2190140

**RE: RESPONSE TO REQUEST FOR ADDITIONAL INFORMATION
(SSD 7317 – MOD 19 – PRECINCT MARKER SIGNAGE)**

Ethos Urban has prepared this letter on behalf of Mirvac Projects Pty Ltd (Mircac) in response to the Department's request for additional information, dated 9 October 2020.

Sign Locations

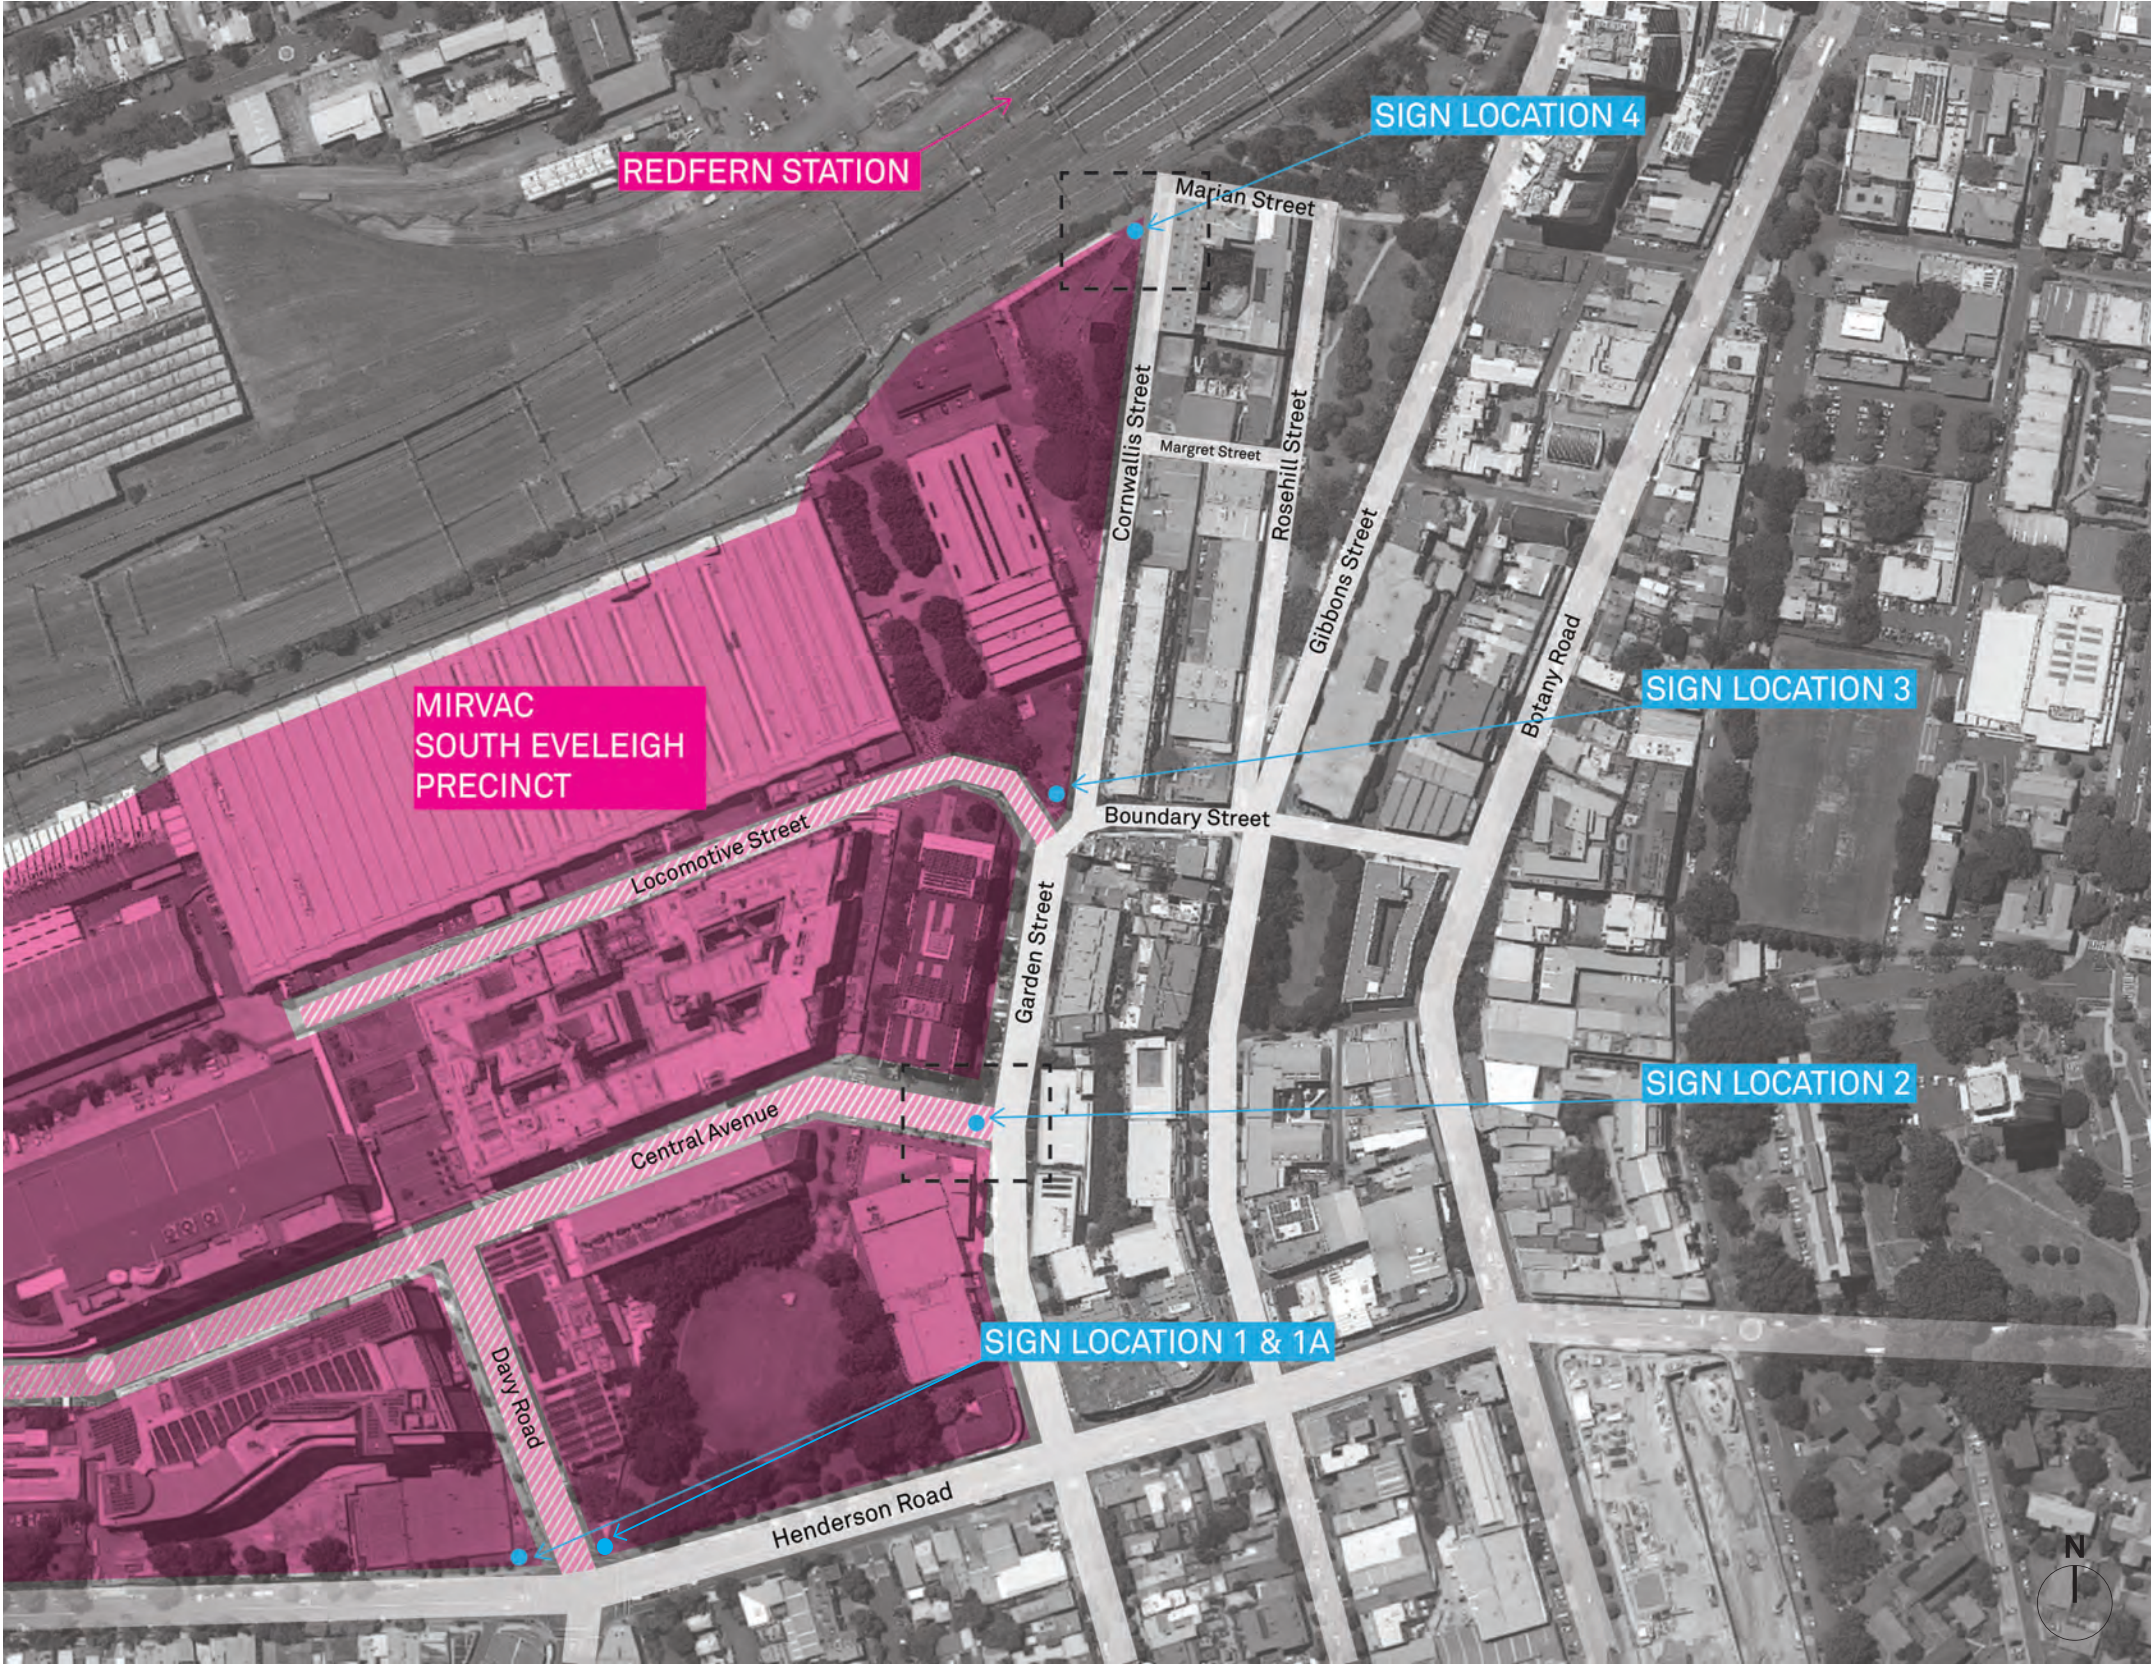
Please provide the Sign Locations Plan (Attachment A pg 7) in the Signage Strategy to reflect the amended design for the Redfern Station sign.

The amended Sign Locations Plan is included within the final and complete Signage Strategy package provided at **Attachment A**.

LIGHTING IMPACT ASSESSMENT -
OUTDOOR SIGNAGE AT CORNWALLIS AND MARIAN STREET, SOUTH EVELEIGH, NSW

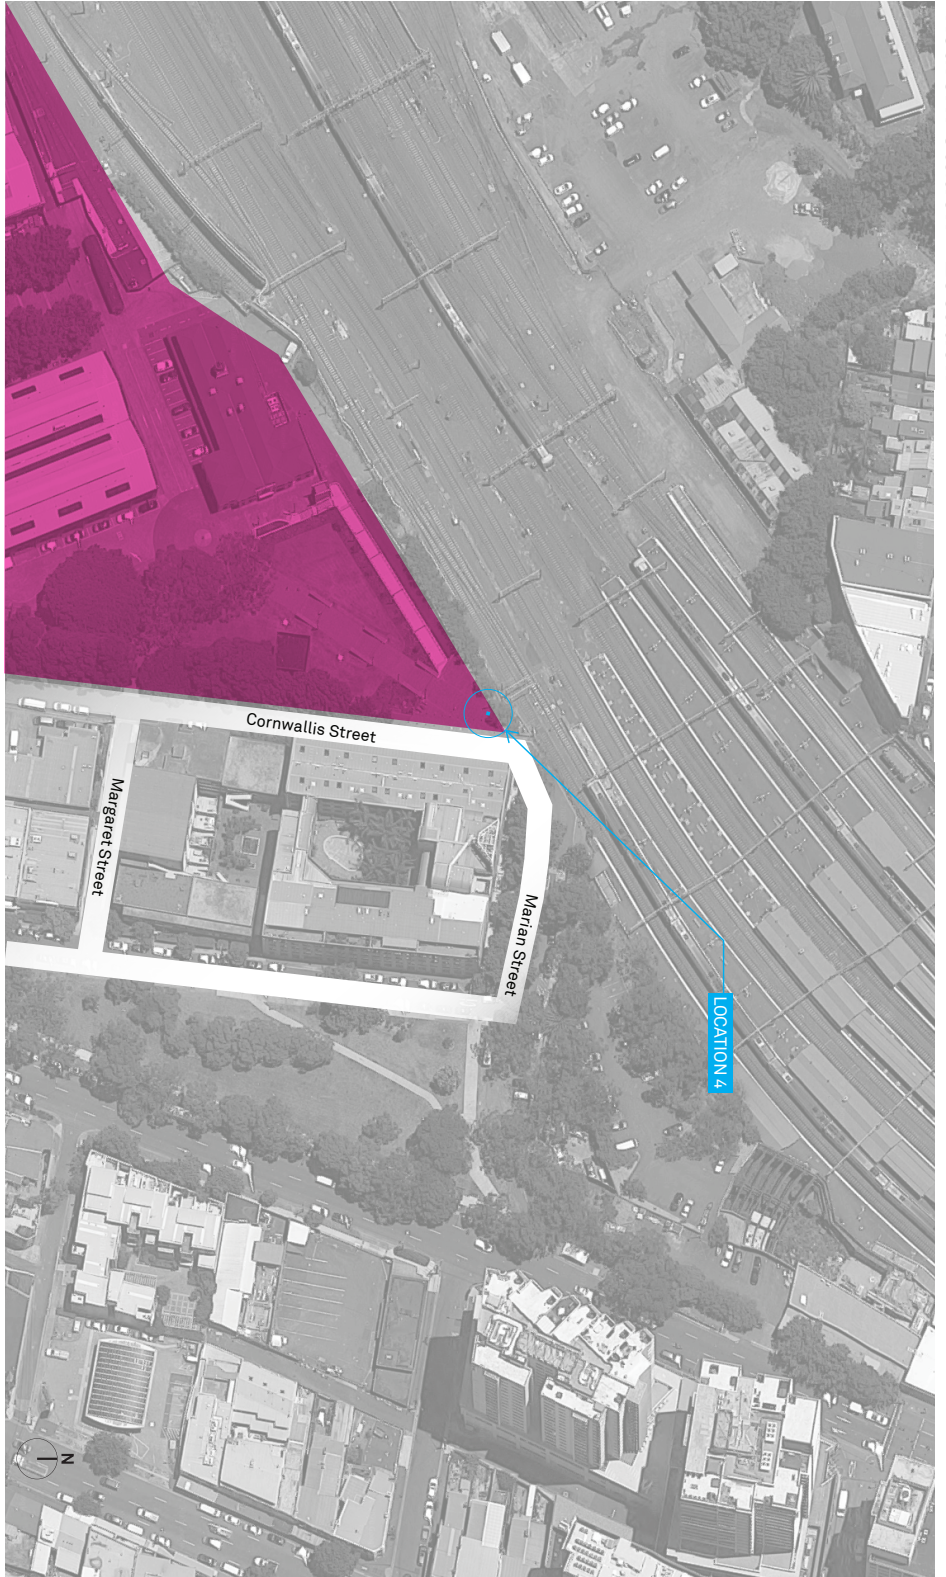
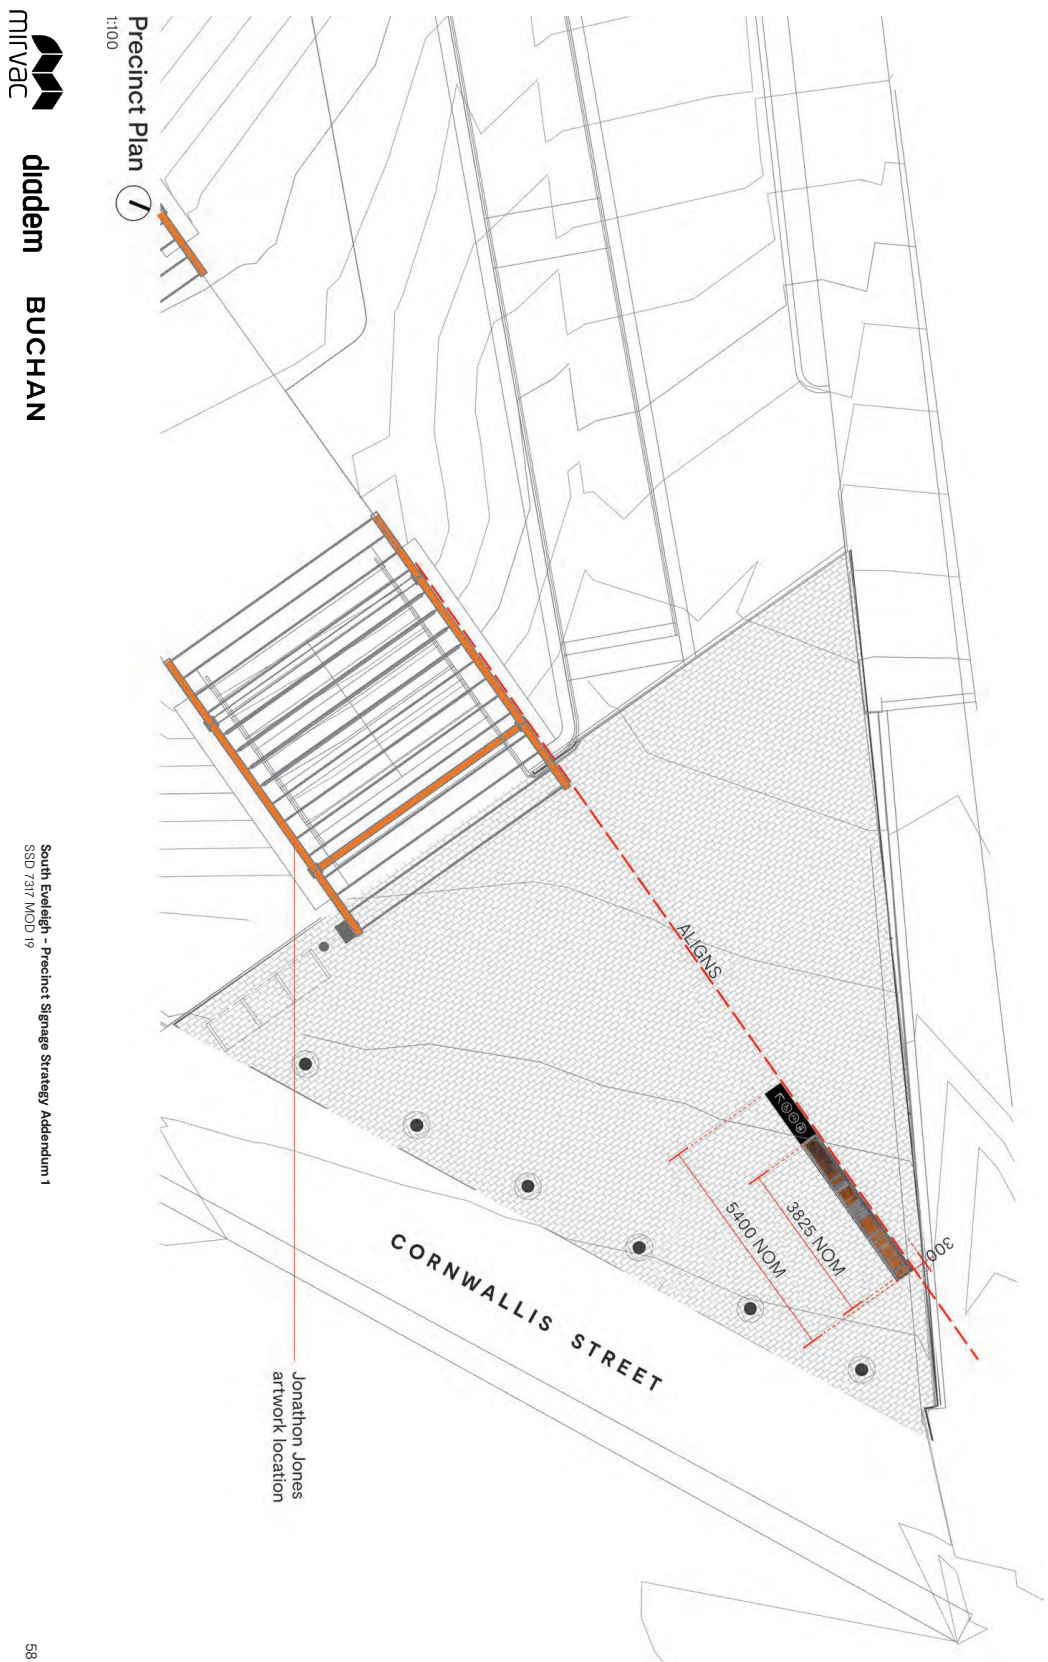
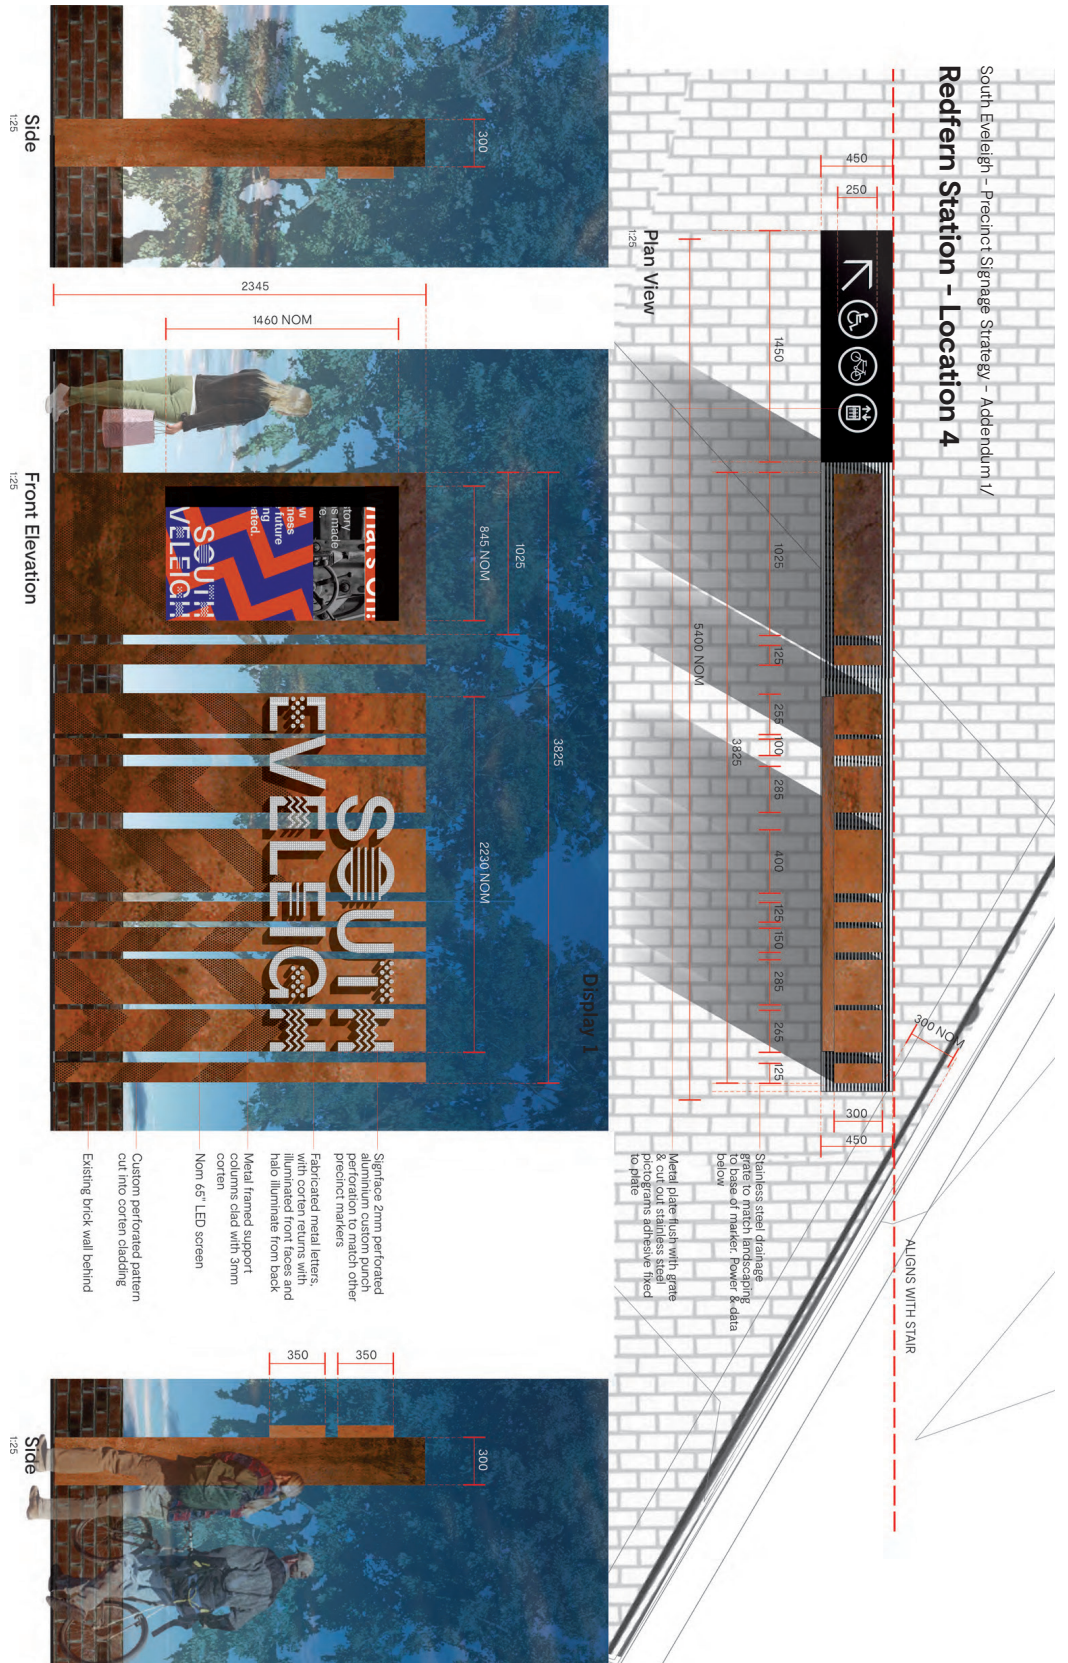
Provide an updated Lighting Report that addresses the following:

- An assessment of the amended Redfern Station sign; and*
- Specifications and management of the proposed dimmed lighting.*

An updated Light Spill Assessment report, prepared by Electrolight is provided at **Attachment B**. It assesses the potential impacts of the light spill from the revised Redfern Station Precinct marker sign design and its compliance with:

In accordance with the methodology applied within the light spill assessment reports prepared for the other Precinct Marker signs on the South Eveleigh site, Electrolight has undertaken modelling in a lighting calculation program (AIG132) to determine the effect of the light spill from the revised Redfern Station sign design on the nearest residential receivers. The results of the modelling confirm, as demonstrated in **Table 1** below that the illuminance levels of the proposed digital screen and the static lettering will comply the maximum illuminance limits specified in AS 4282 and the Sydney DCP.

In addition, the threshold increment of the Redfern Station sign from traffic on Marian Street approaching Cornwallis Street and the Railway approaches at Redfern Station has also been calculated. With a maximum allowable threshold increment % of 20%, Electrolight confirm that the revised Redfern Station sign will give rise to a 0.39% for pre-curfew (6am to 11pm) and 0% for post curfew (11pm to 6am) threshold increment for any traffic approach which does not exceed the maximum allowable under AS 4282.

Overall, Electrolight confirm that the revised design for the Redfern Station precinct marker sign complies will relevant requirements of AS 2019 Control of Obtrusive Effects of Outdoor Lighting and the Sydney Development Control plan (Signs and Advertisements) 2012, subject to the relevant recommendations set out in within the report.
